Addendum #1

**Peoples Regional Opportunity Program
Phase III Scattered Site Affordable Housing
Anderson & Cumberland Streets, Portland, Maine 04101
North Street, Westbrook, Maine 04101**

January 28, 2005

4 THIRD FLOOR  
M1.1 3/16" = 1'-0"

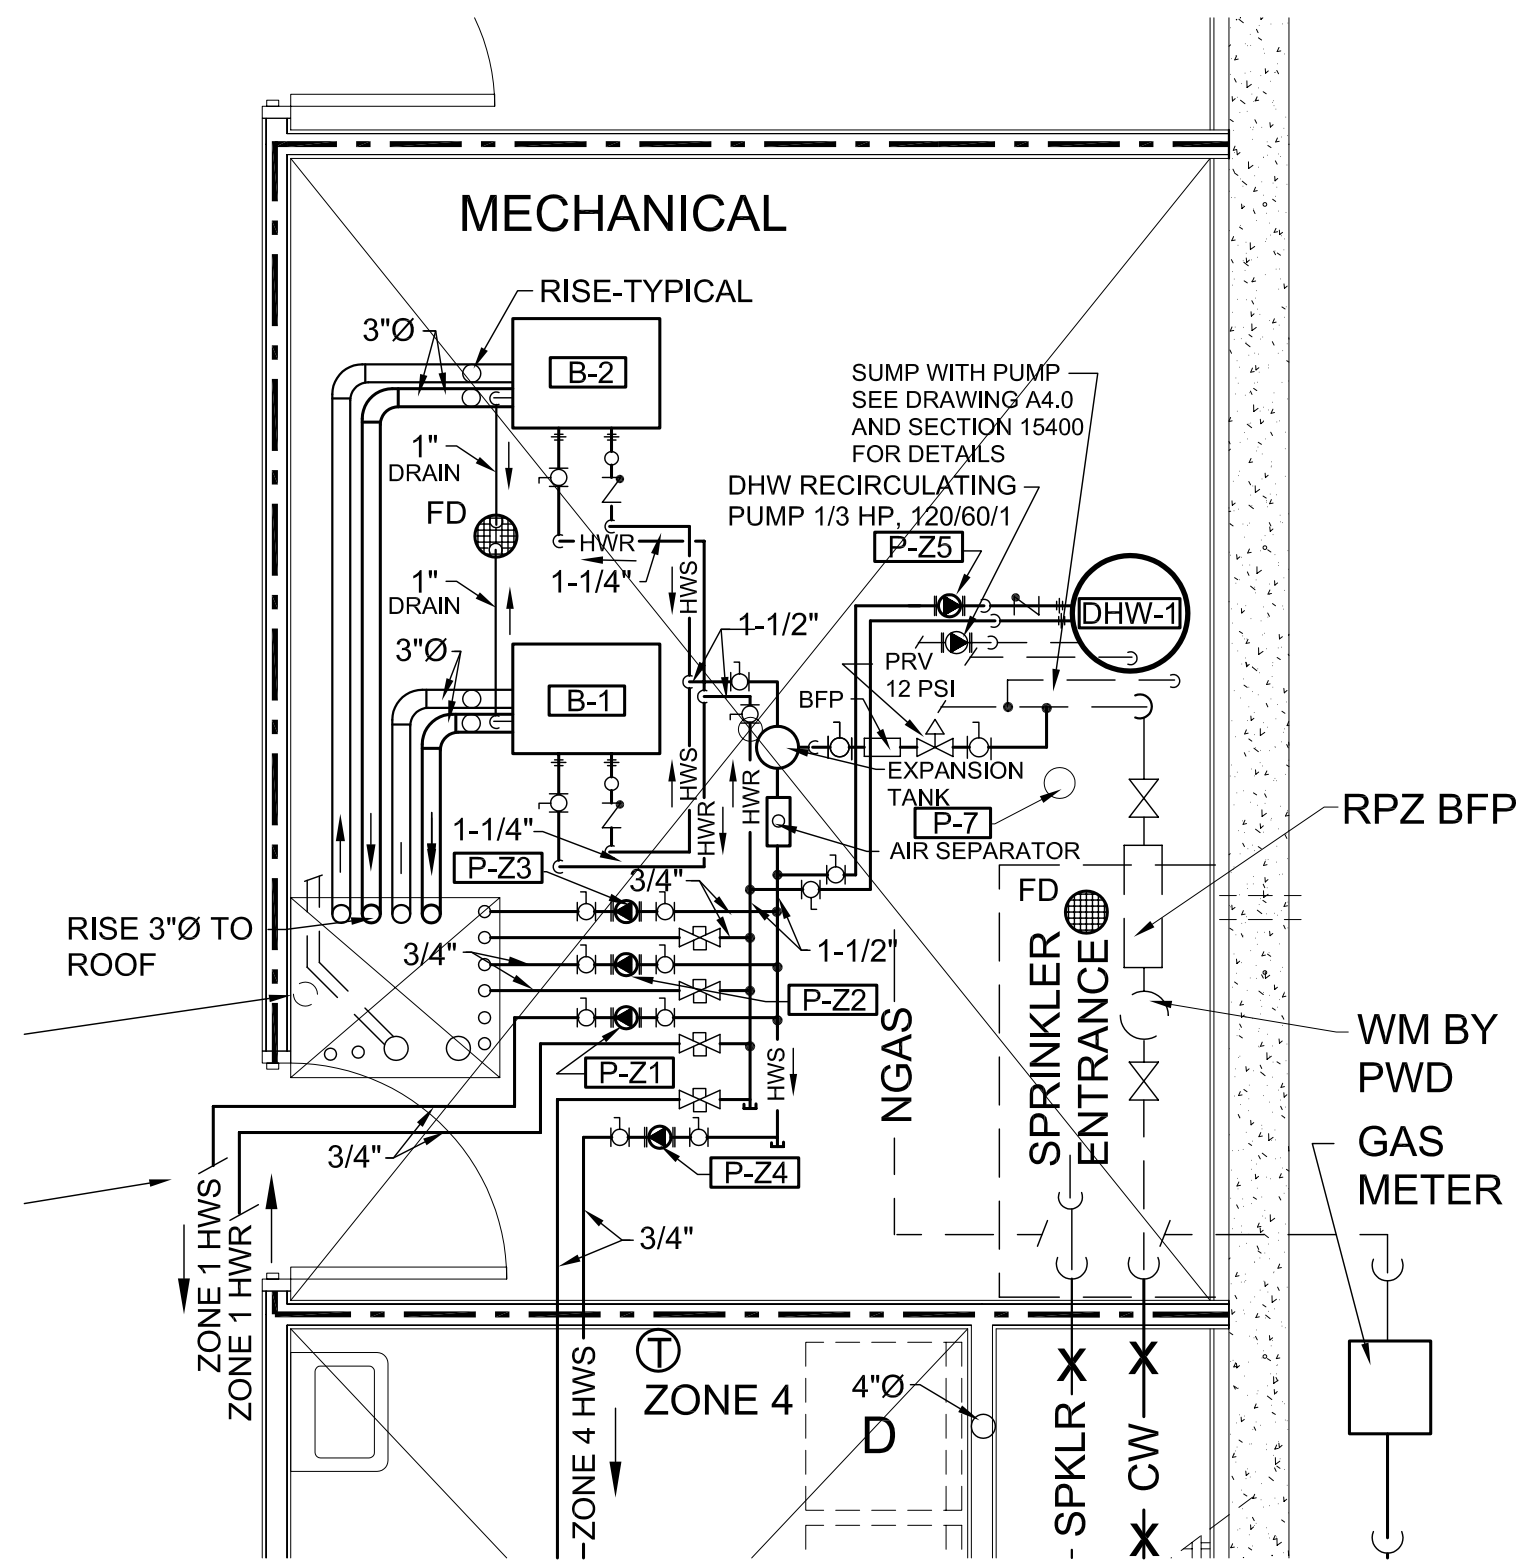
- 1-1 Drawing C6 (Portland, all sites), dated 1/14/05
- 1-2 Drawing C3.0 (Westbrook, all sites) , dated 1/14/05
- 1-3 Drawing M1.1 (Portland Anderson 2), dated 1/25/05
- 1-4 Drawing M1.2 (Portland Anderson 2), dated 1/25/05
- 1-5 Drawing M1.1 (Portland Anderson 3), dated 1/25/05
- 1-6 Drawing M1.2 (Portland Anderson 3), dated 1/25/05
- 1-7 Drawing M1.1 (Portland Anderson 2), dated 1/14/05
- 1-8 SkC-1, dated 1/28/05
- 1-9 SkC-2, dated 1/28/05
- 1-10 SkC-3, dated 1/28/05
- 1-11 SkC-4, dated 1/28/05
- 1-12 SkA-1, dated 1/28/05
- 1-13 SkA-2, dated 1/28/05
- 1-14 SkA-3, dated 1/28/05
- 1-15 SkA-4, dated 1/28/05

A2.3

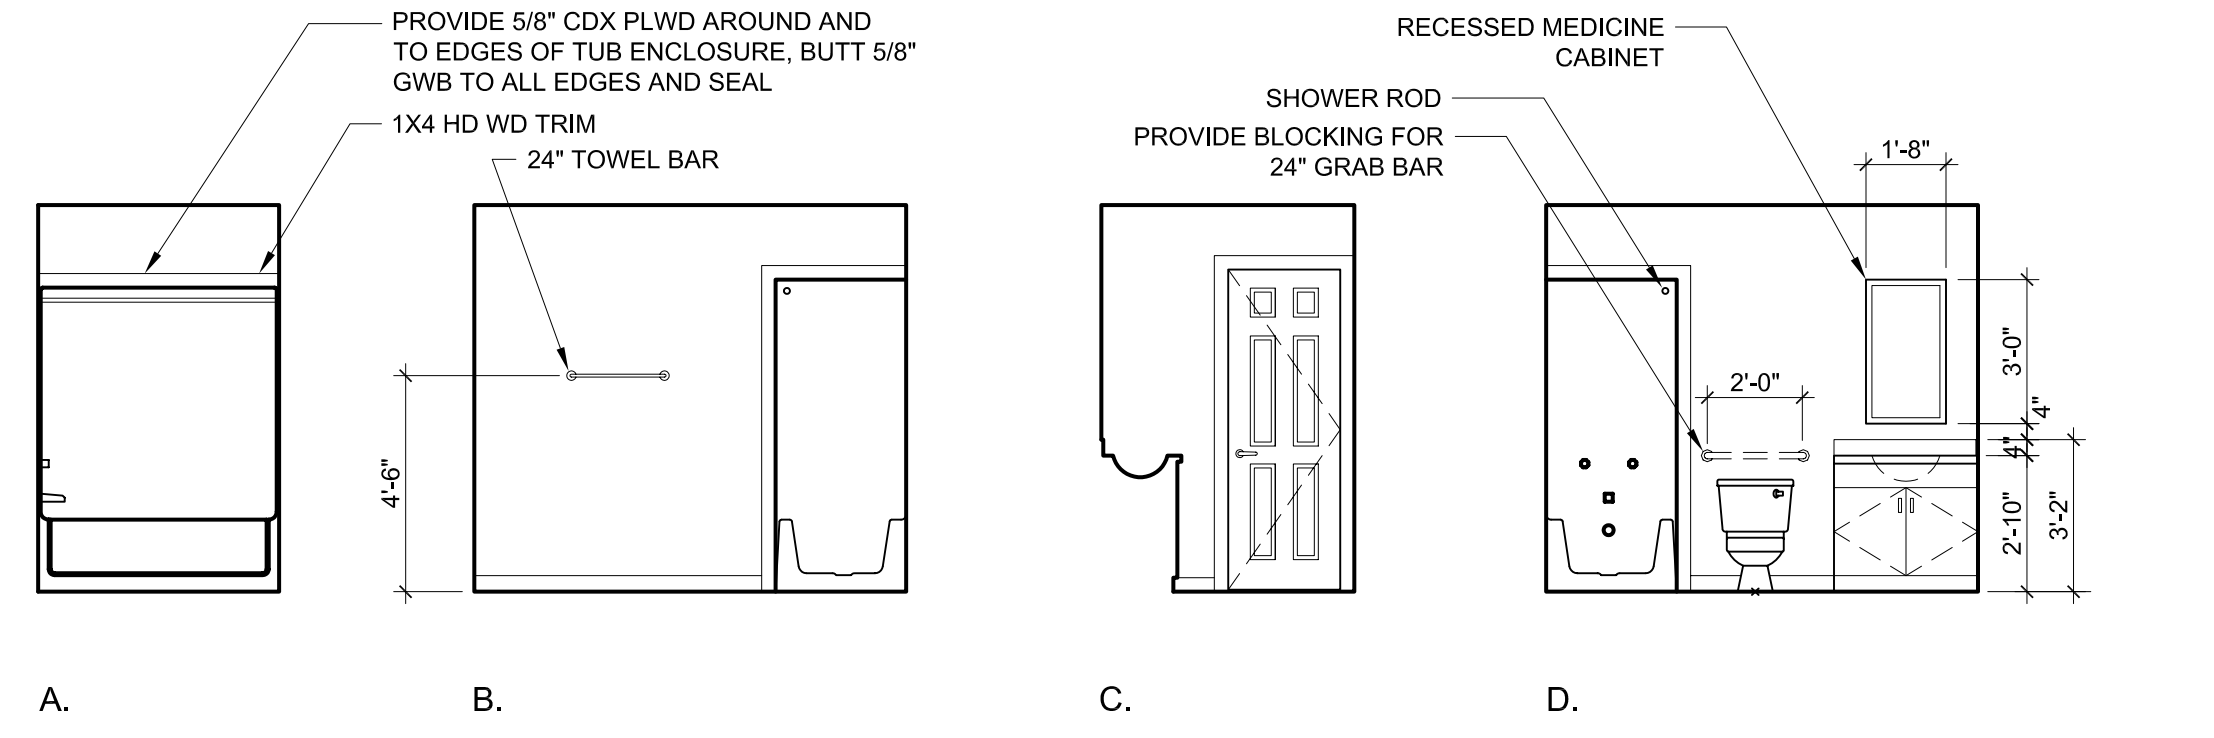
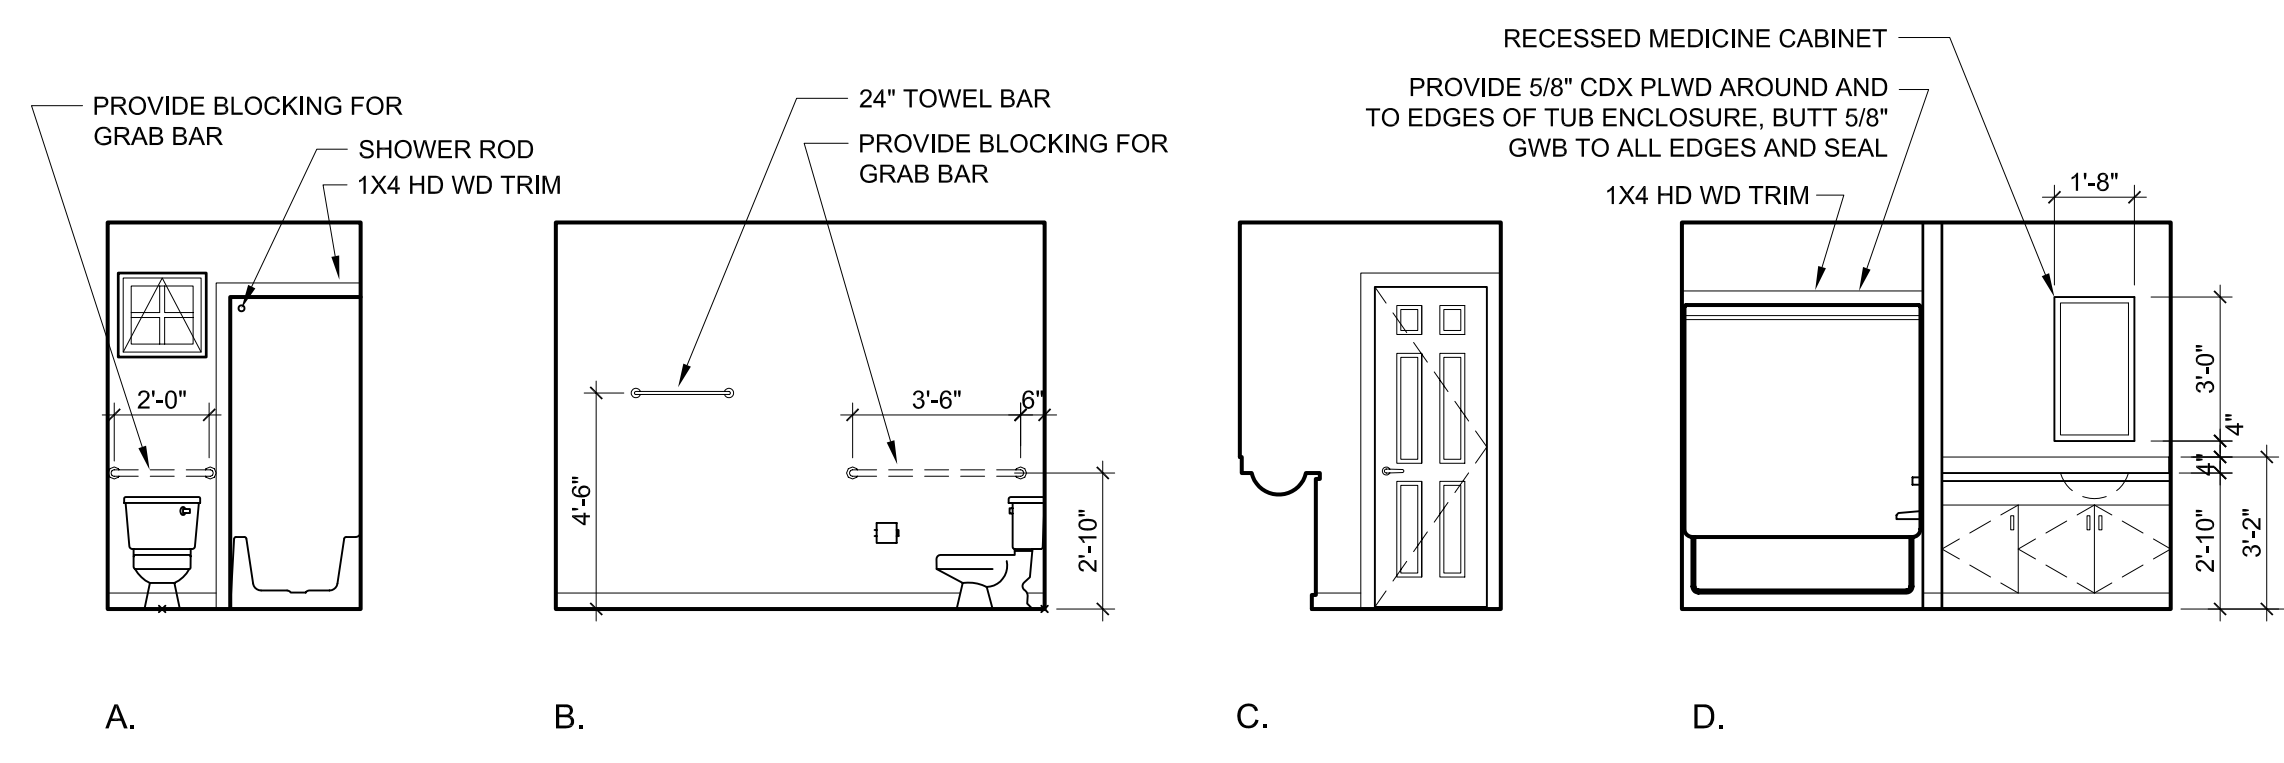
1-24	A1.0, A1.1, A1.2,		All sites Add note 11 for underlay @ linoleum floors.
1-25	A.0, A1.1, A1.2,		All sites Add note 11 for underlay @ linoleum floors.
1-26	A2.3	3, 4	All sites Add soffits above upper cabinets for vent duct.
1-27	A4.0	Anderson 3,4	Add geotech fabric per Geotech reports
1-28	A4.0	15, 17 North St. 3,4	Add geotech fabric per Geotech reports
1-29	A1.0, A1.1, A1.2,		All sites General Finish notes - Add note 11 for underlay @ linoleum floors.
